Address: The Coach House, 18A, Abbey Road, Huddersfield, hd88ep

Application number: 2026/70/90885/E	
What is the application for?:	Variation conditions 2 (plans), 5 (openings), 6 (PD rights) on previous permissi
Address of the site or building:	The Coach House, 18A, Abbey Road, Shepley, Huddersfield, HD8 8EP
Postcode:

east elevation

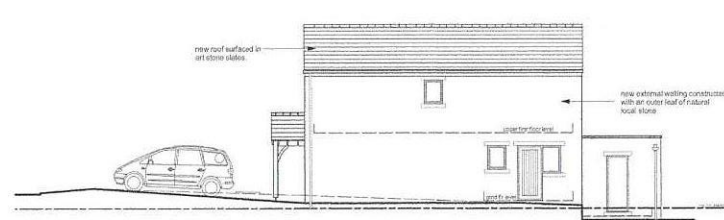
Type of comment: A general comment	
Do you wish your comments to be published on the website anonymously?	No
<p>I live at the adjacent property on the East side.</p> <p>I appreciate a bathroom ideally needs a window, but this causes issues with privacy both for us (including our children) and for the new house.</p> <p>If this window is to be placed there, in the pursuit of privacy and not being being able to see people in a state of undress, please can the window be stipulated as:</p> <ol style="list-style-type: none">1. only top opening portion and not a full opening window2. frosted glass. <p>Thanks, Stephen Robinson</p>
